The Glen at Widefield Filing No. 12

Transportation Memorandum

LSC Responses to TIS Redline Comments

Number: 1 Author: jchodsdon Subject: Sticky Note Date: 10/20/2022 5:55:22 PM
LSC Responses to EPC TIS Redline comments

Figure 2
Site Plan

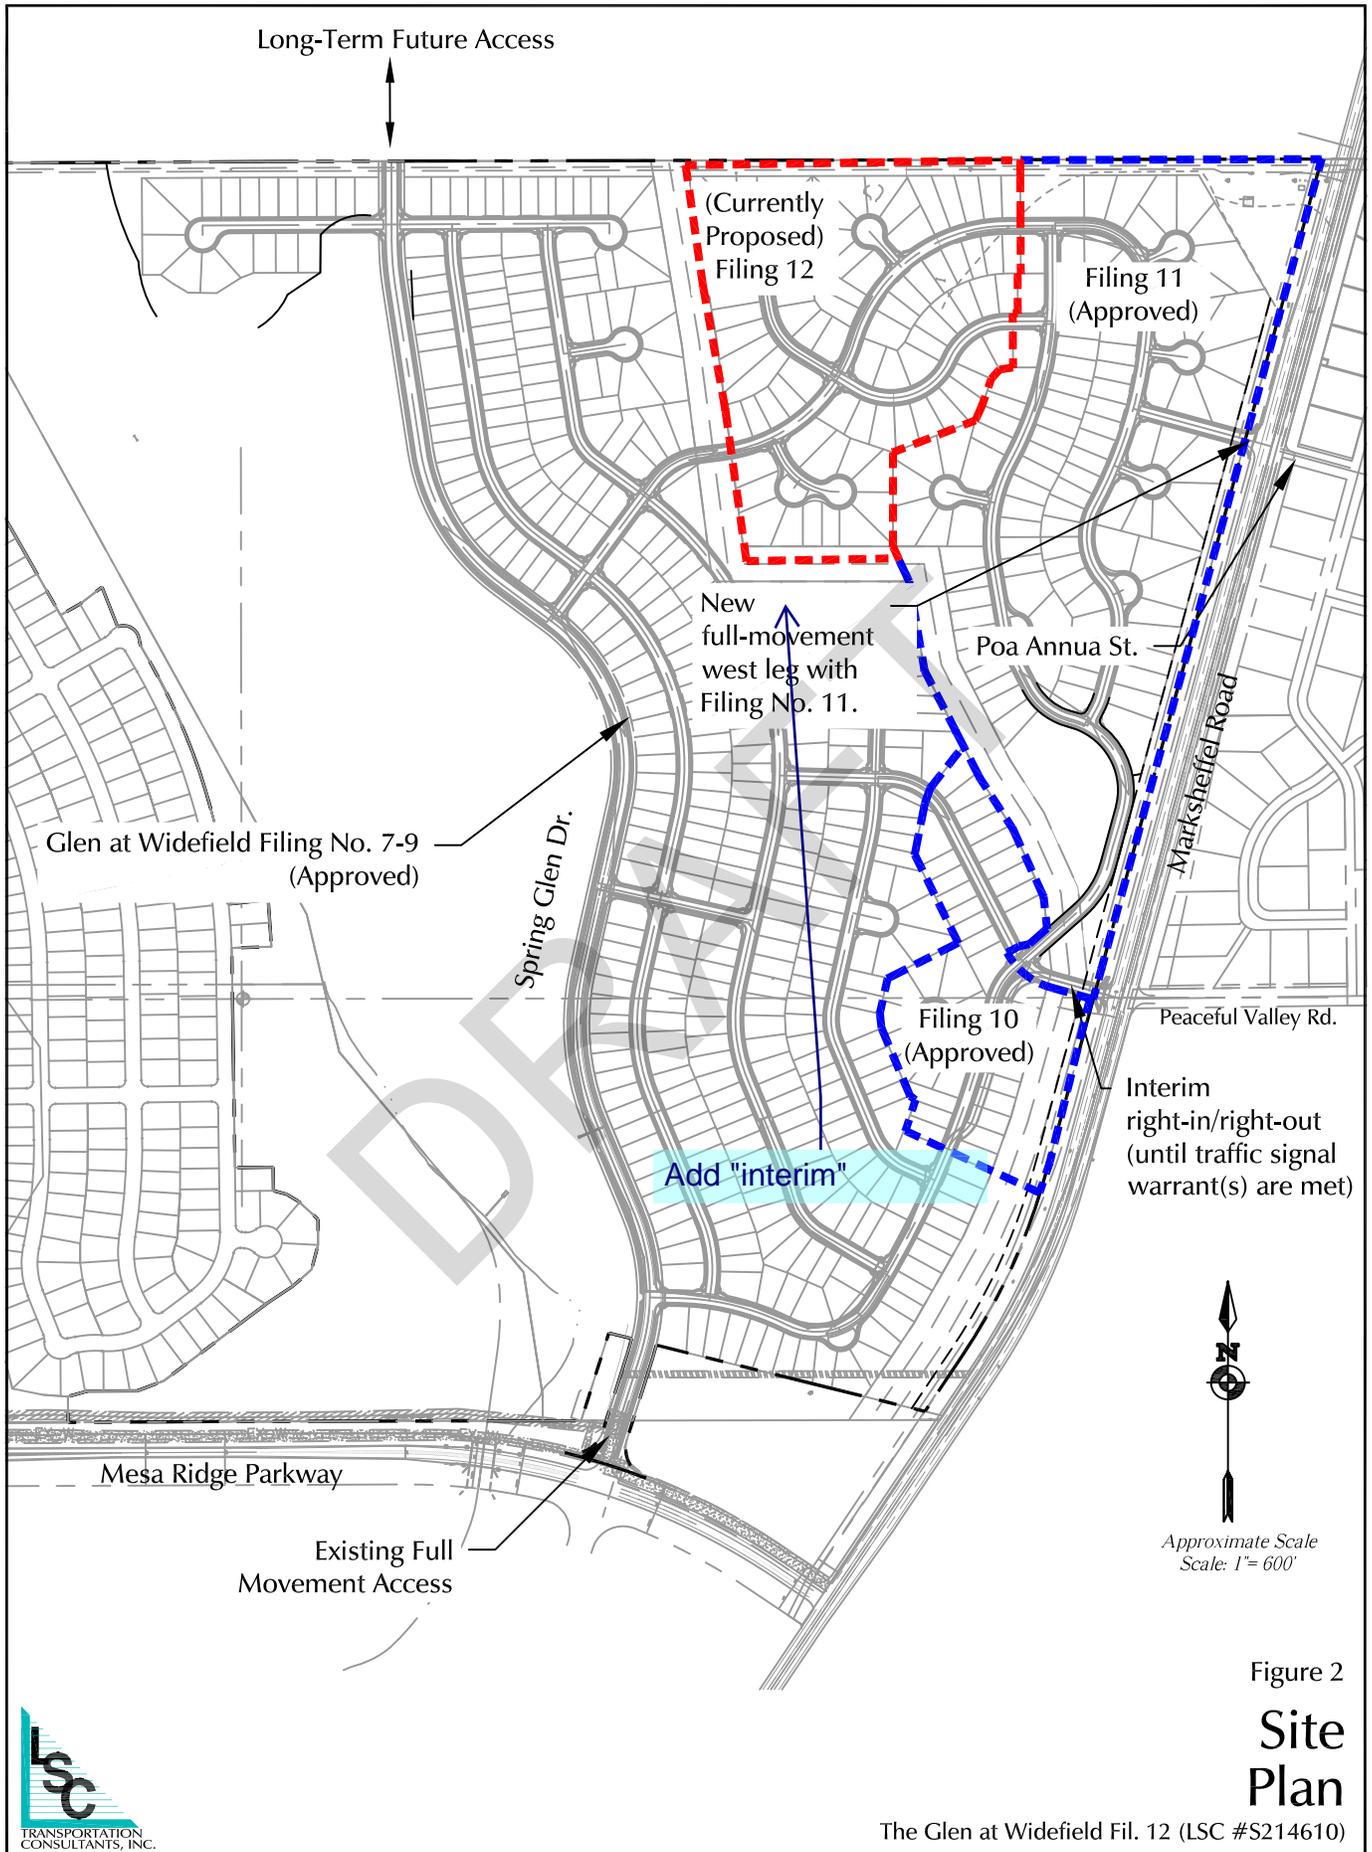
Number: 1 Author: Daniel Torres Subject: Callout Date: 8/11/2022 9:40:12 AM

Add "interim"

Author: kdferrin Subject: Sticky Note Date: 10/21/2022 8:20:33 AM
LSC Response: Revised as requested
